KITTITAS COUNTY COMMUNITY DEVELOPMENT SERVICES

December 12, 2019

RE: Swiftwater Storage Conditional Use Application (CU-20-00006)

WLC PROPERTY HOLDINGS LLC
SITE PLAN

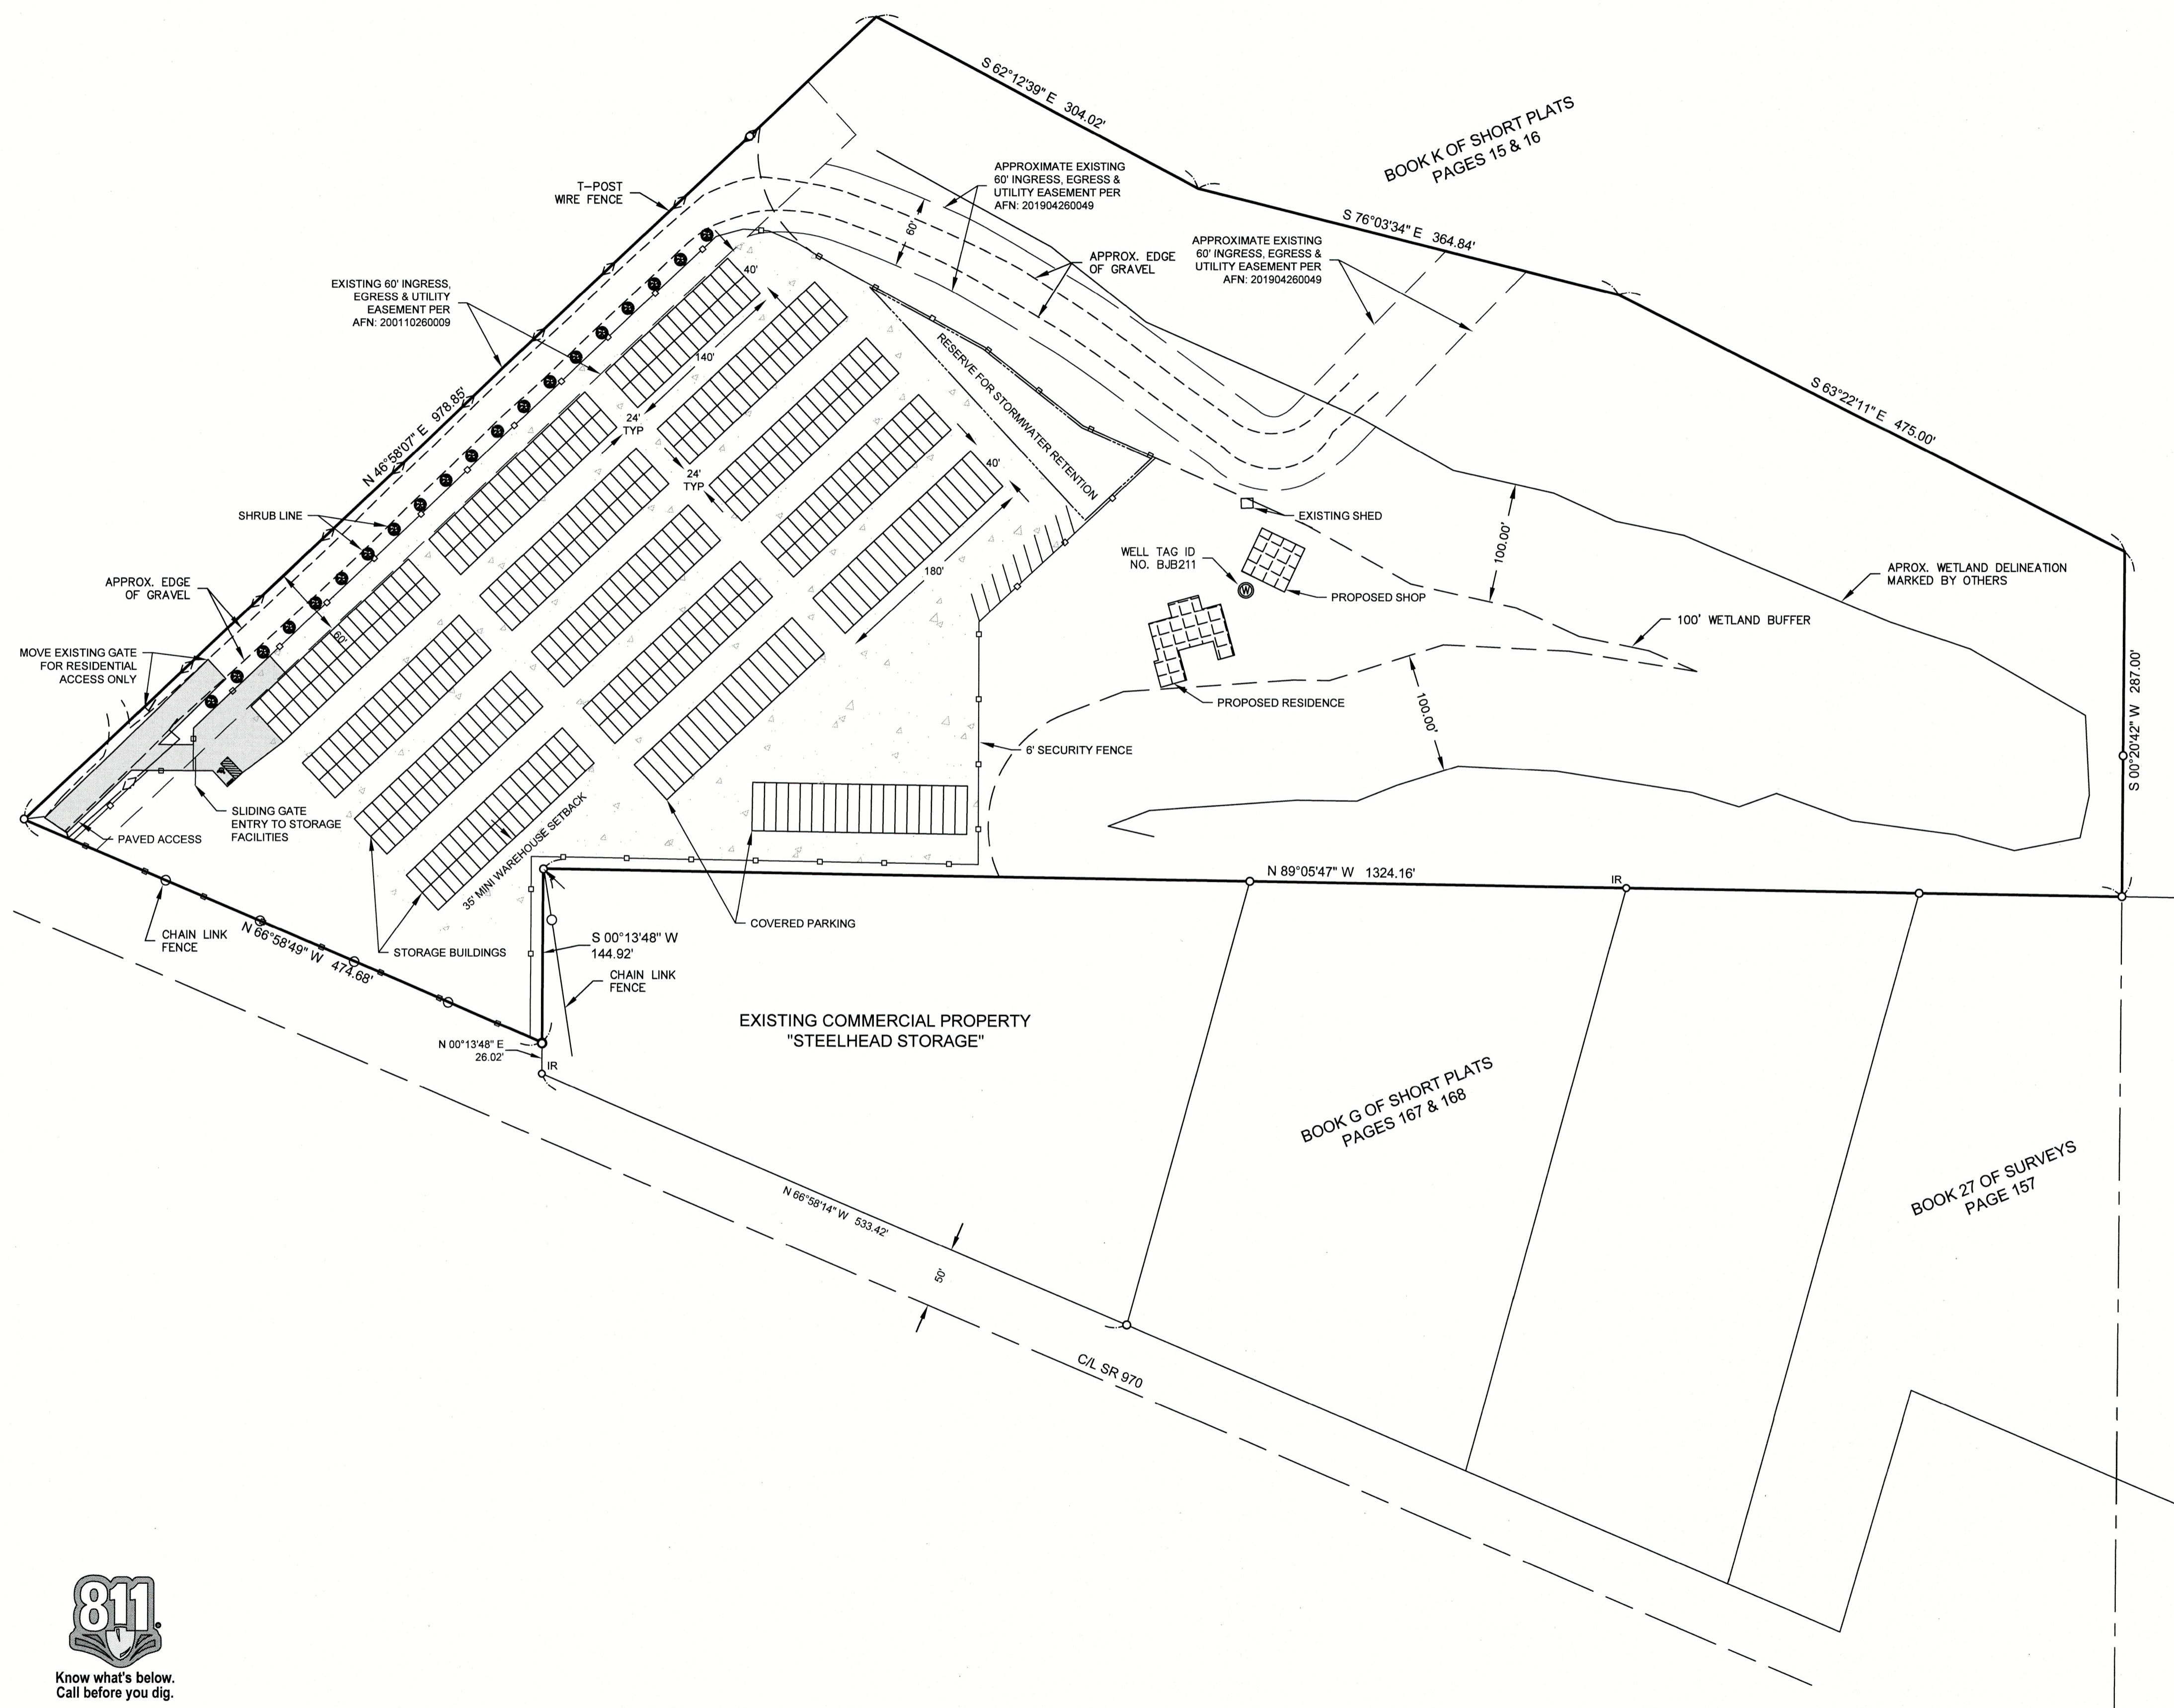
- a. Revised site plan depicting :
 - The orientation of the storage buildings, specifically the face of each storage structure.
 - All setbacks must be depicted on the face of the site plan. The existing site plan shows structures next to the existing access easement. Front lot line setbacks (25 feet) apply to all access easement.
 - Please show the Well setback on the face of the site plan.
- b. Revised narrative depicting:
 - Plans for aesthetic improvements and/or sight screening pursuant to KCC17.15.060.1 footnote #14
